Subject: AL/49/20/PL Byfields & Nightingale Cottage

I am your case officer. I have been reviewing the application this morning and have a number of comments.

Dwellings 3 & 6

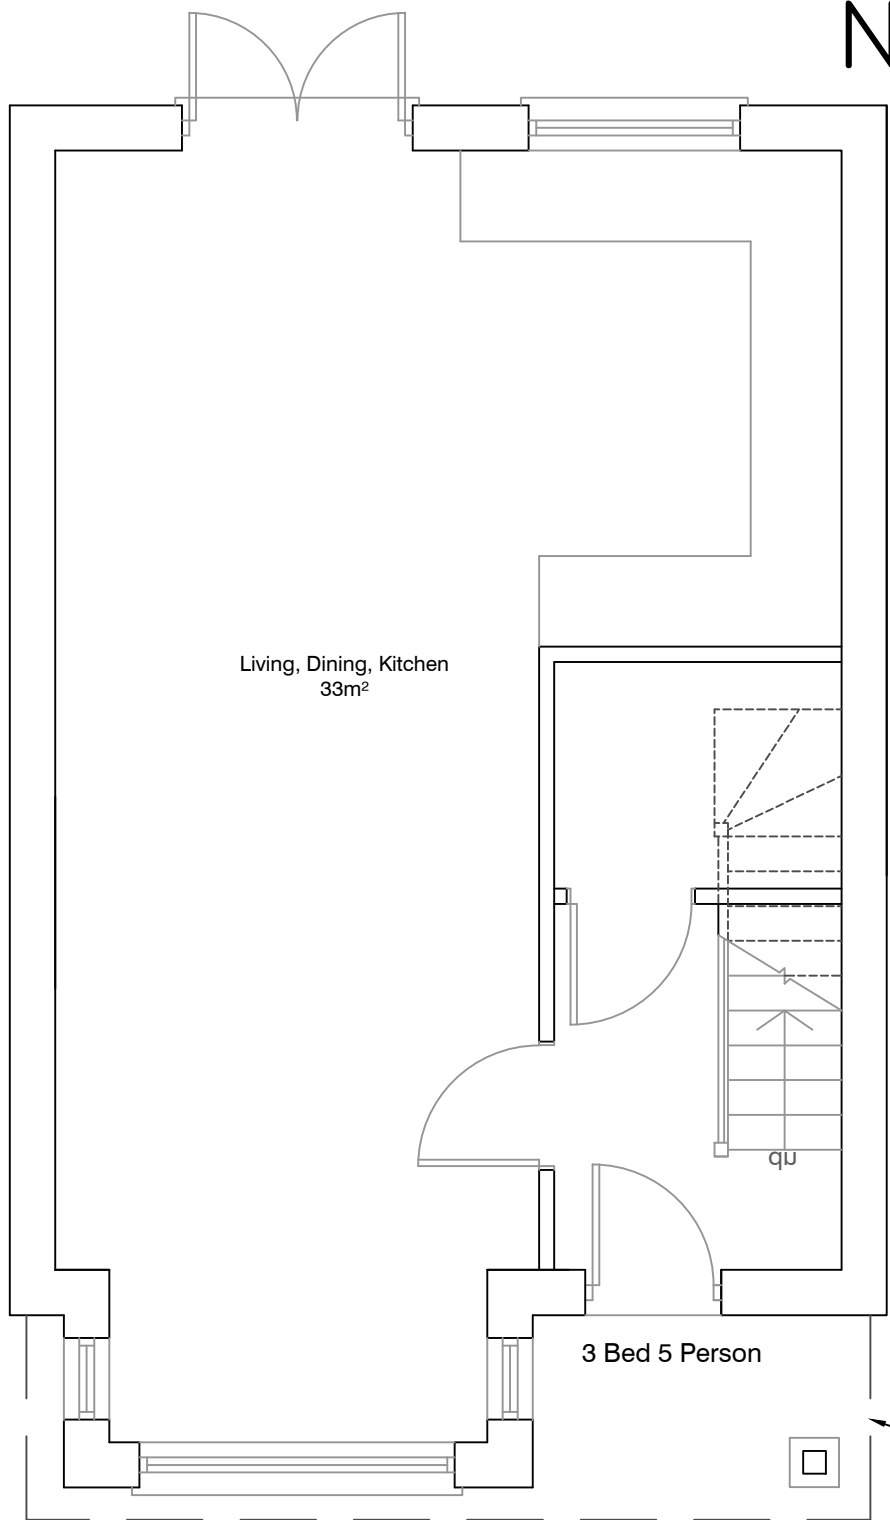
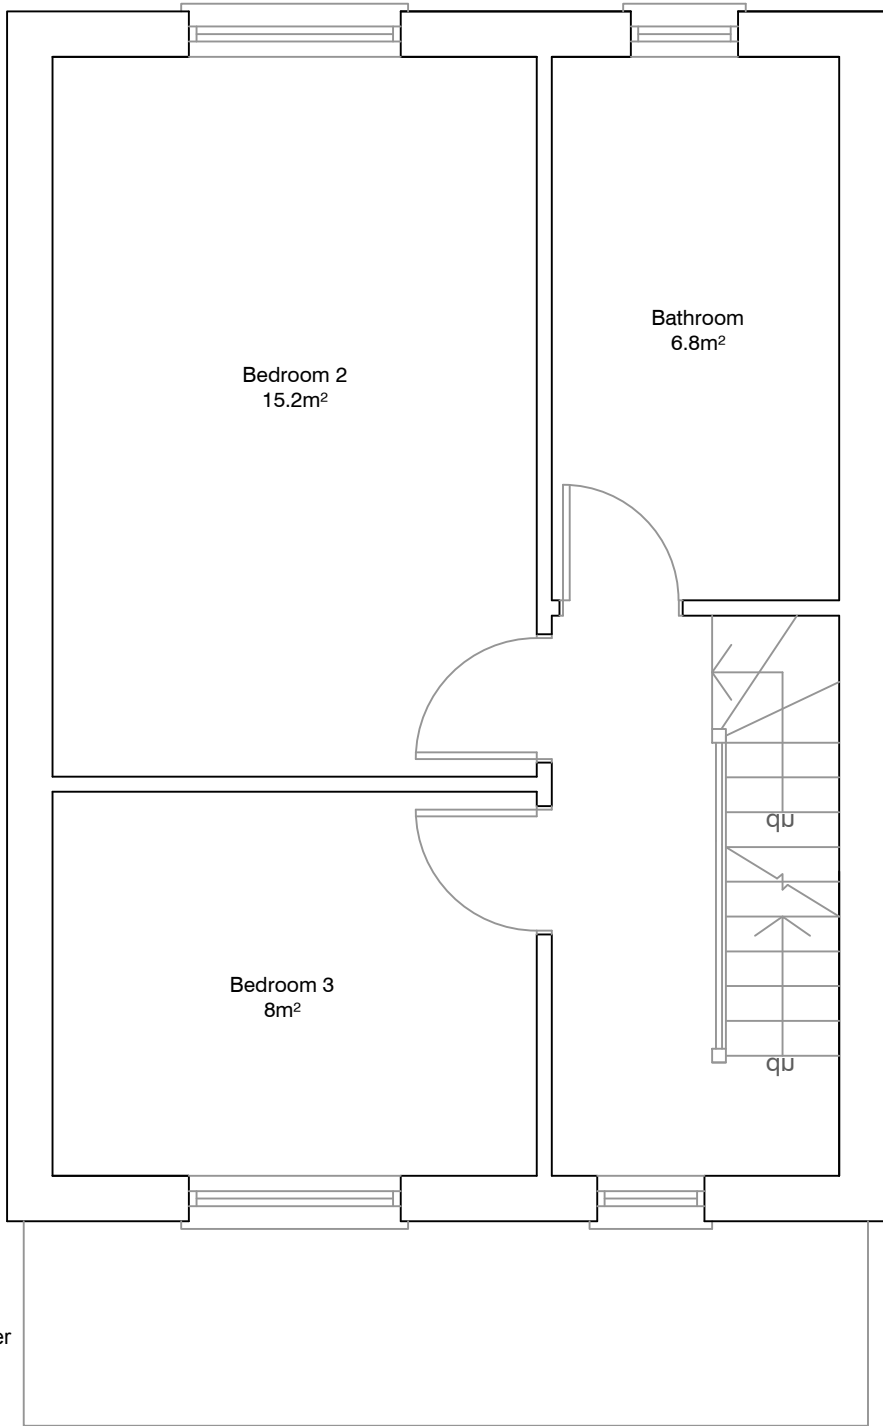
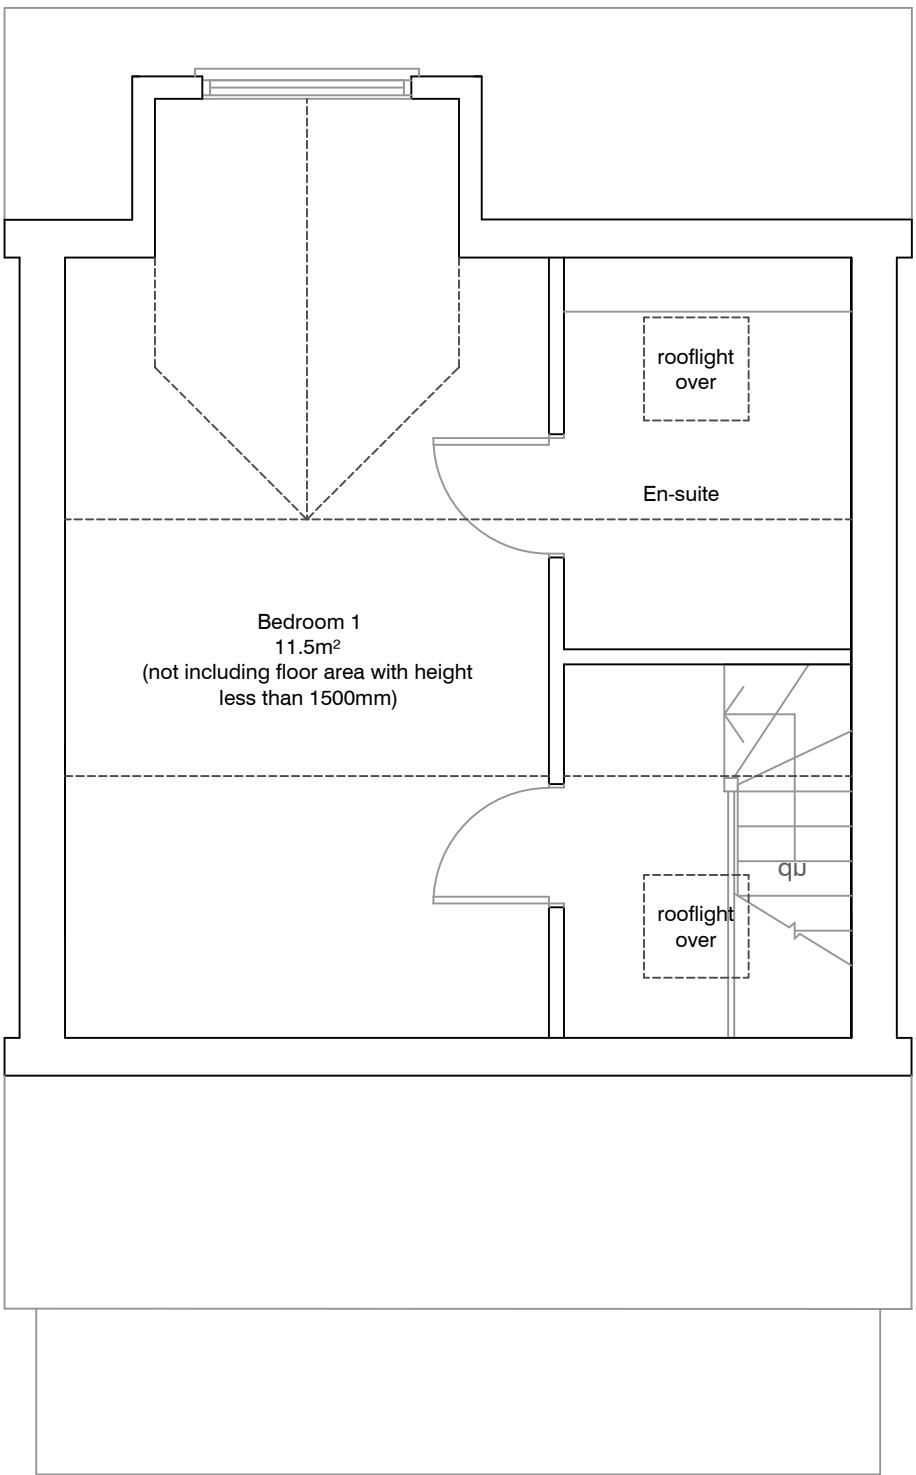
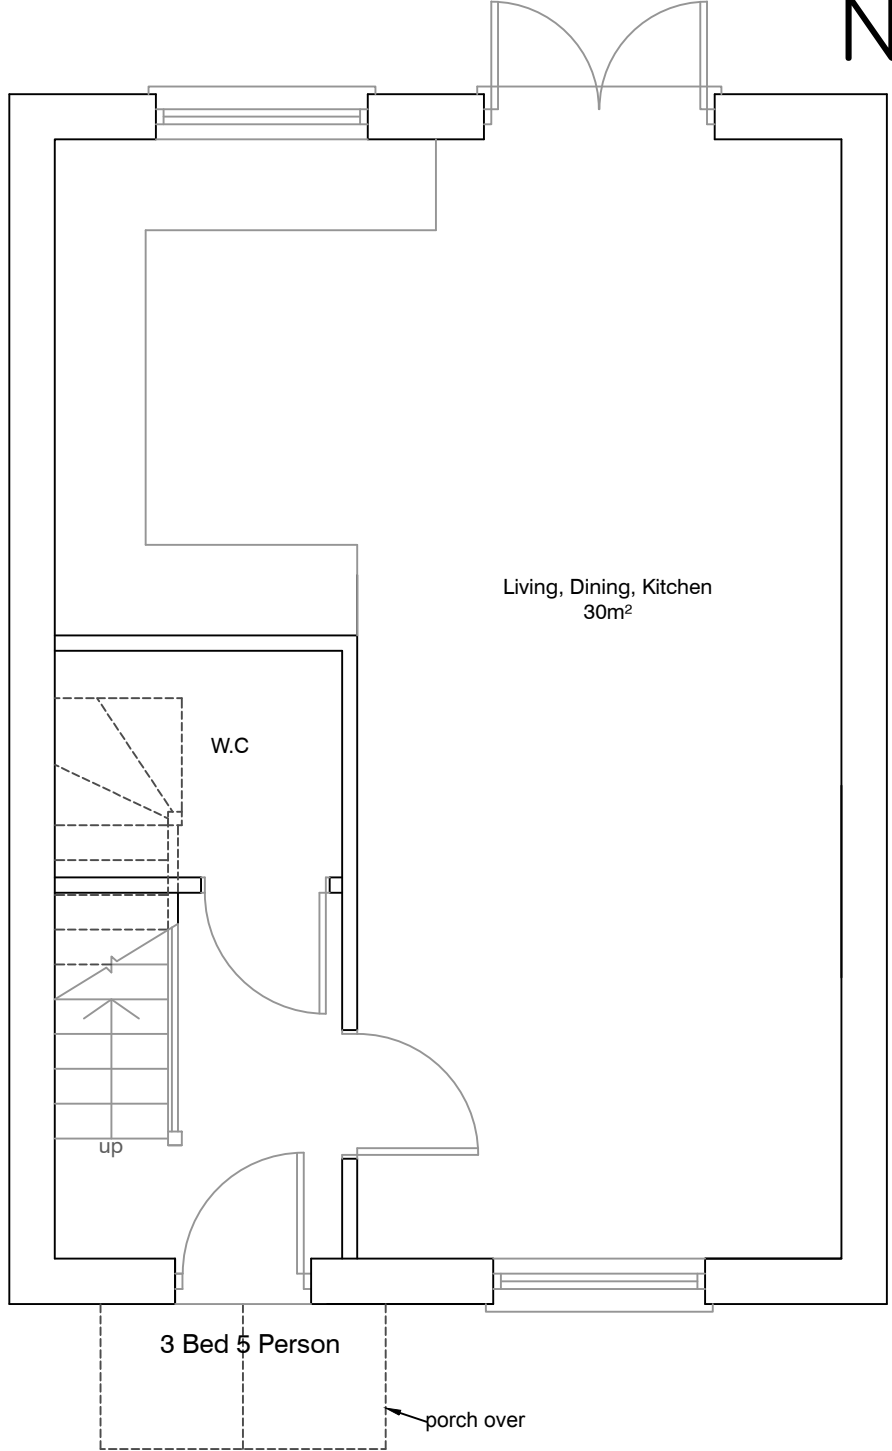
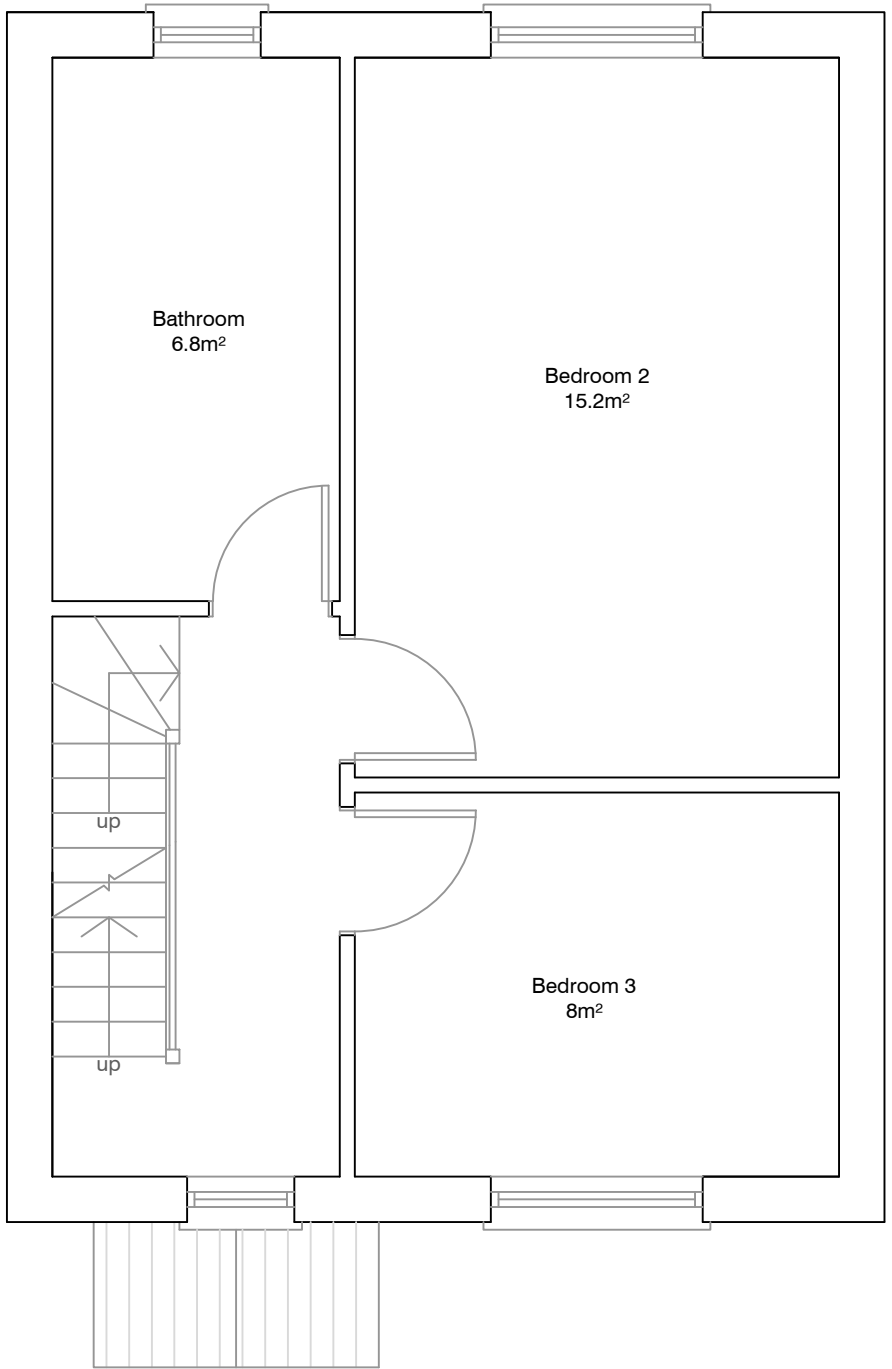
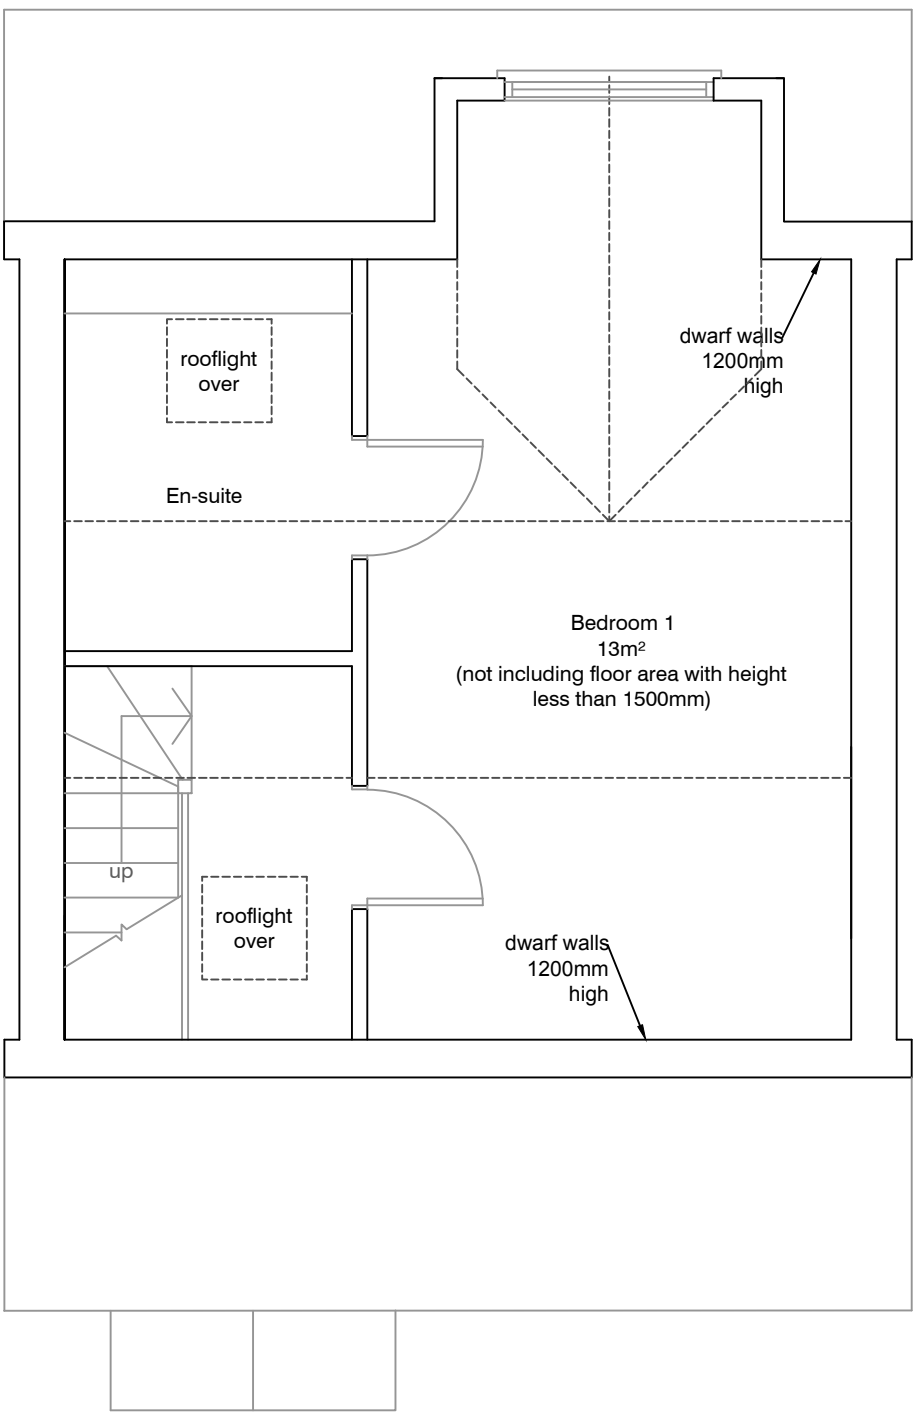
I have been measuring the floor areas of the new dwellings and other built development (garages) and I get the following:

3-6 - 107.27m² each so 429.08m²

Garages for 3-6 - 16.5 each so 66m²

So by my calculations, the total proposed is 851.04m² which is different to yours (686m²). My measurements have been done with our web tool and may not be as accurate as CAD and also I have not excluded internal walls to save time but there is still a clear difference which may or may not be down to garages not being included and I would invite you to double check the figures given on your CIL form.
